**RE: SYDNEY METRO VICTORIA CROSS OVER STATION
DEVELOPMENT (SSD8874)**

Victoria Cross Over Station Development Response to Submissions Report

Figure 2 Extract of Ground Floor Concept Plan

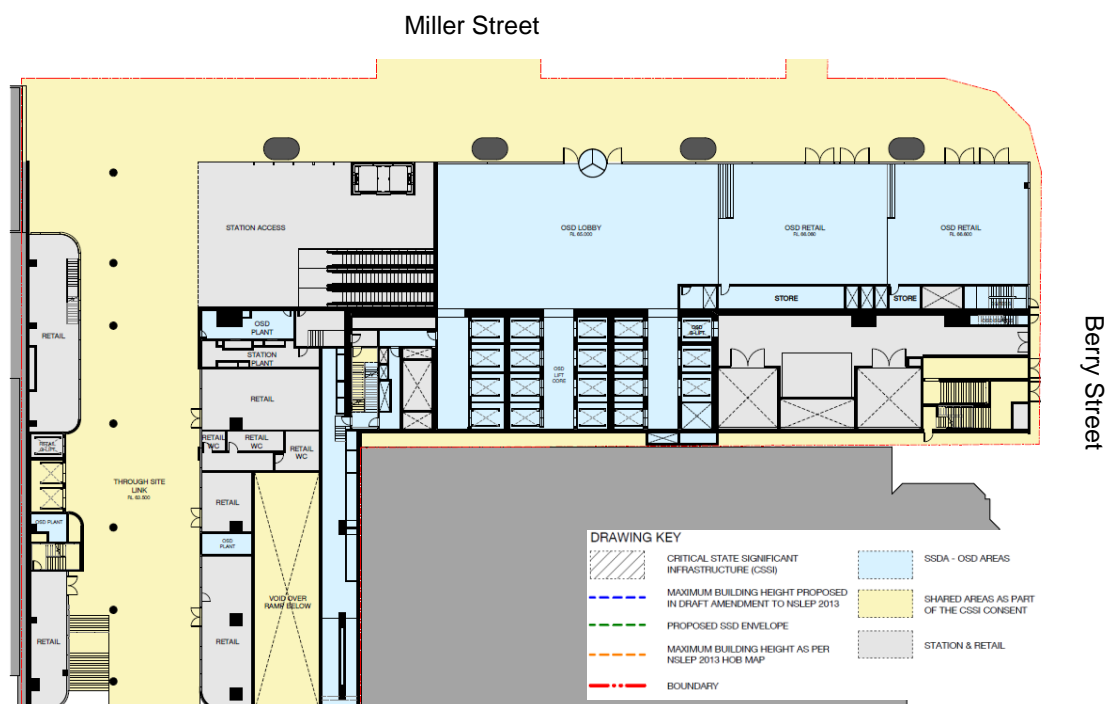
The relationship of the northern corner of the building with Berry Street has been misrepresented in the plans with the existing delivery bays (serving multiple buildings) shown as footpath. The actual available footpath along Berry Street would actually be less than 2m. This is wholly inadequate for such a high traffic pedestrian area.

The concept stage of the Victoria Cross Station development indicated an open forecourt on the corner of Berry St and Miller St as shown in Figure 01 below. Subsequent design drawings show this important space as 'glassed-in' and no longer publicly accessible (Figure 02). Pedestrian modelling undertaken under the CBD Transport masterplan indicates a volume increase of 300% at this particular junction. The removal of this publicly accessible space will be detrimental to the public domain outcome and does not meet council strategic guidelines for the future amenity for North Sydney CBD.

Figure 02 highlights the areas of space that require review. There is scope for these spaces to be re-designed to meet the original design concept objectives. We request that this space be reviewed to meet future pedestrian growth figures as well as provide an outstanding urban design outcome for the most prominent sun-lit corner of the CBD.
